RWE Renewables UK Solar and Storage Limited

Proposed Peartree Hill Solar Farm (Application Reference: EN010157) Request to approve changes/corrections to the DCO Application (“Change Request”)

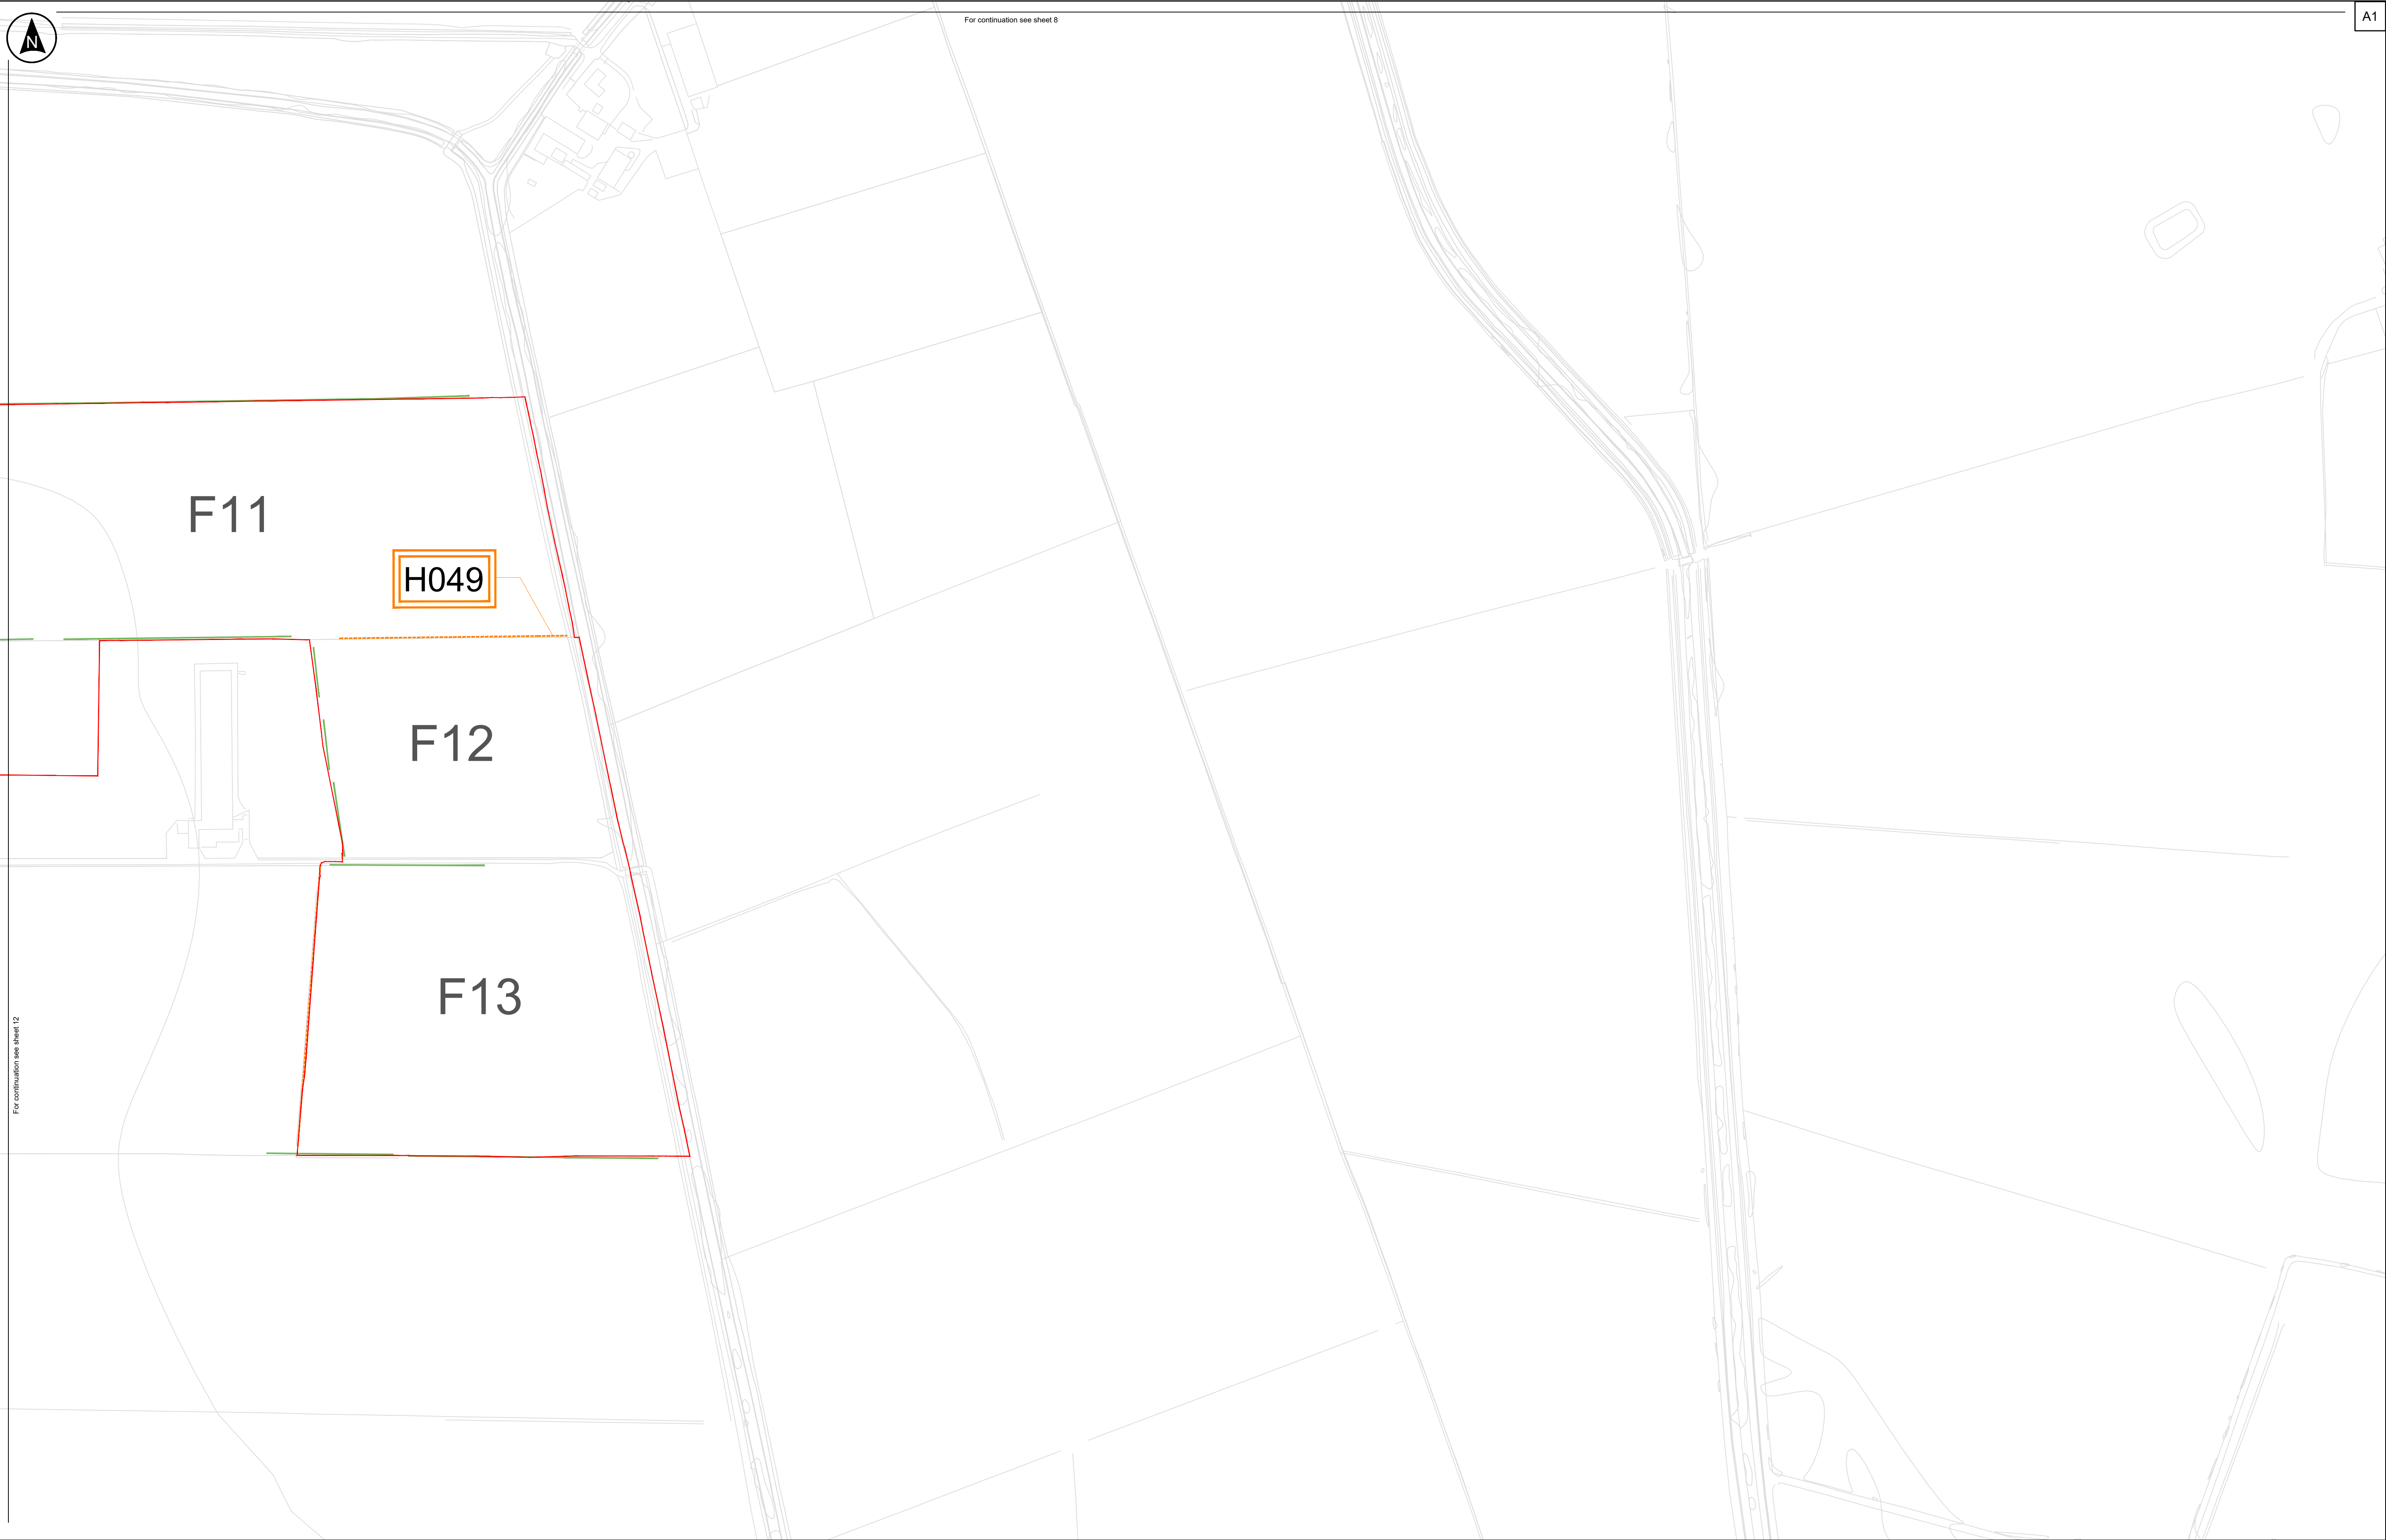
2. **Change/correction 2:** to remove three plots from the Order Limits along Carr Lane which are currently proposed for temporary possession (Plots 10-4, 10-5 and 10-6) but which are no longer required.

EN010157/APP/2.6	Crown Land Plans	Key plan only required to be updated to reflect the removal of plots 10-4, 10-5 and 10-6 from the Order Limits	No - as the change would be indecipherable at this scale
	EN010157/APP/2.8	Tree Preservation Order and Hedge-row Plans (clean version)	Key Plan and Sheet 10 of 17 updated to reflect the removal of plots 10-4, 10-5 and 10-6 from the Order Limits	Yes
	EN010157/APP/2.9	Traffic Measures Plan (clean version)	Key Plan and Sheet 10 of 17 updated to reflect the removal of plots 10-4, 10-5 and 10-6 from the Order Limits	Yes
	EN010157/APP/2.11	Statutory/Non-statutory Sites or Features of Nature Conservation and Habitats of Protected Species, Important Habitats or Other Diversity Features Plan (clean version)	Key Plan and Sheet 10 of 17 updated to reflect the removal of plots 10-4, 10-5 and 10-6 from the Order Limits	Yes
	EN010157/APP/2.12	Water Bodies in a 'River Basin Management Plan' Plan (clean version)	Key Plan and Sheet 10 of 17 updated to reflect the removal of plots 10-4, 10-5 and 10-6 from the Order Limits	Yes

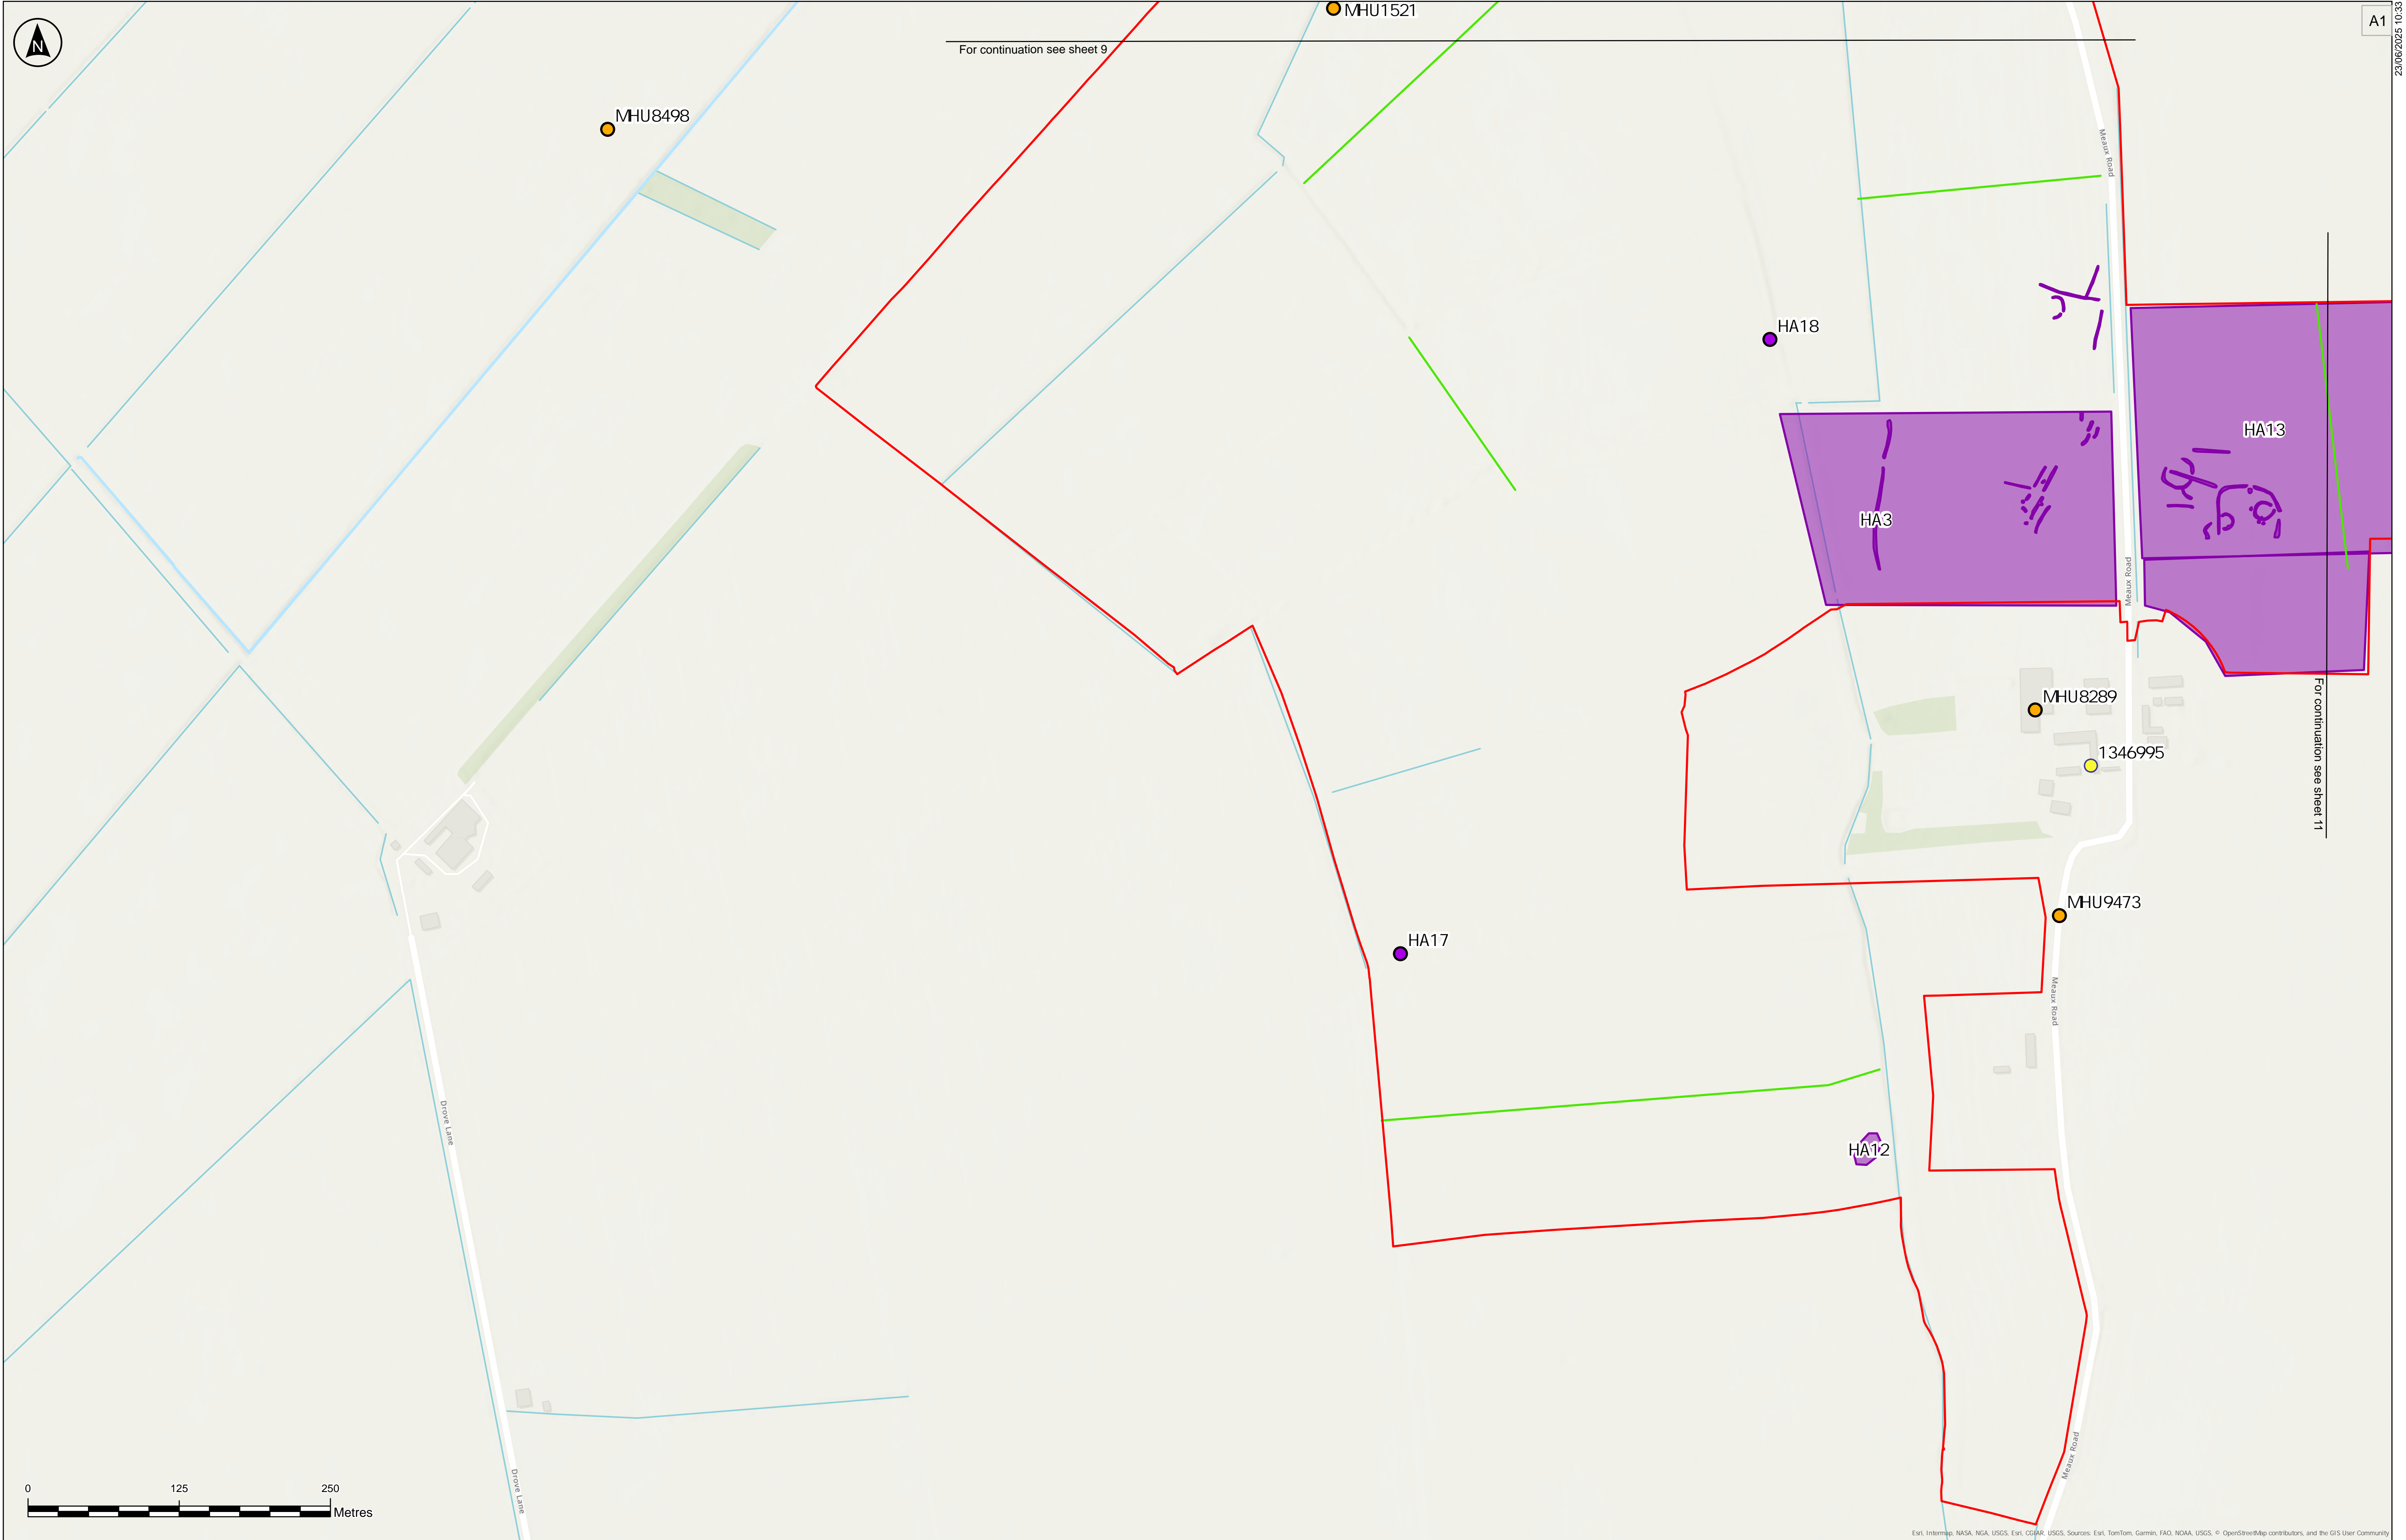
EN010157/APP/2.13	Statutory/Non-statutory Sites or Features of the Historic Environment Plan (clean version)	Key Plan and Sheet 10 of 17 updated to reflect the removal of plots 10-4, 10-5 and 10-6 from the Order Limits	Yes
3	Draft Development Consent Order			
	EN010157/APP/3.1	Draft Development Consent Order (clean and	Updated to reflect the removal of plots 10-4, 10-5 and 10-6 from Schedule 10 of the	Yes
